Centennial Coal

Response to Submissions

Mannering Colliery – Extension of Mine Project

Section 75W Modification to Project Approval PA 06_0311

Figure 1 Proposed Fassifern Seam with respect to earlier mining in the same seam (green – proposed, grey – existing)

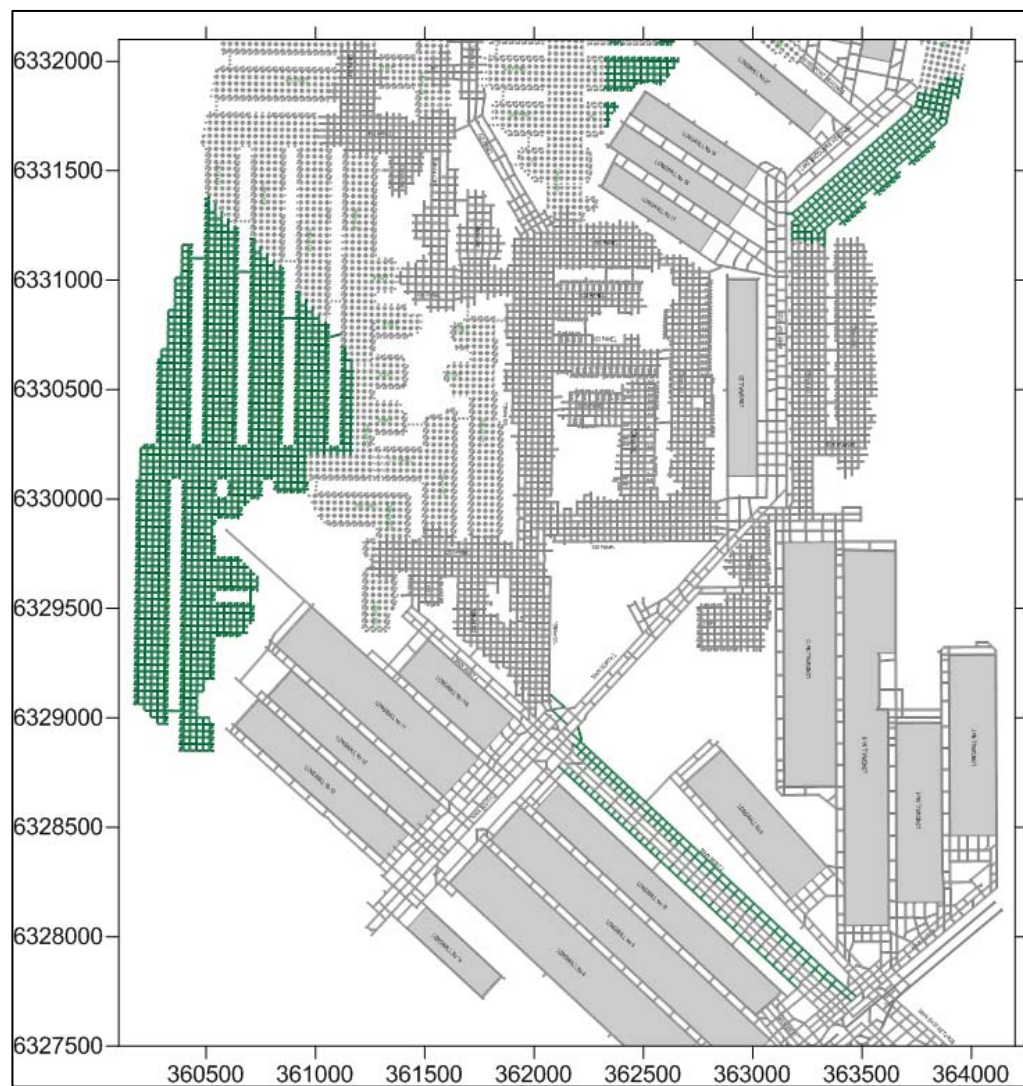
Is information contained in the Appendix I subsidence assessment consistent with predictions that subsidence will not exceed 20 mm. (DP&I)

Further investigations have been undertaken by Centennial Mannering since the application was lodged and it has been determined that Centennial Mannering will not be seeking approval to mine within the Great Northern Seam as part of the application. As such Centennial Mannering is now only seeking a modification to Project Approval PA 06_0311 to allow for the extension of underground mining operations within the Fassifern Seam as described within Environmental Assessment. The following documentation has been prepared to address the change in proposed mining:

- A revised figure (Appendix 1) showing the Proposed Project Site boundary which supersedes the Figure 10 presented in the Environmental Assessment;
- A revised Statement of Commitments (Section 5.0) which supersedes the Statement of Commitments presented in Section 8.0 of the Environmental Assessment; and
- A new subsidence report (Appendix 2) reflecting the proposed mining in the Fassifern Seam only (Seedsman Geotechnics Pty Ltd, 25 July 2012) which supersedes the previous subsidence report (Seedsman Geotechnics, August 2011).

The proposed mining within the Fassifern Seam will achieve long-term stable pillars resulting in less than 20 millimetres of subsidence on the surface.
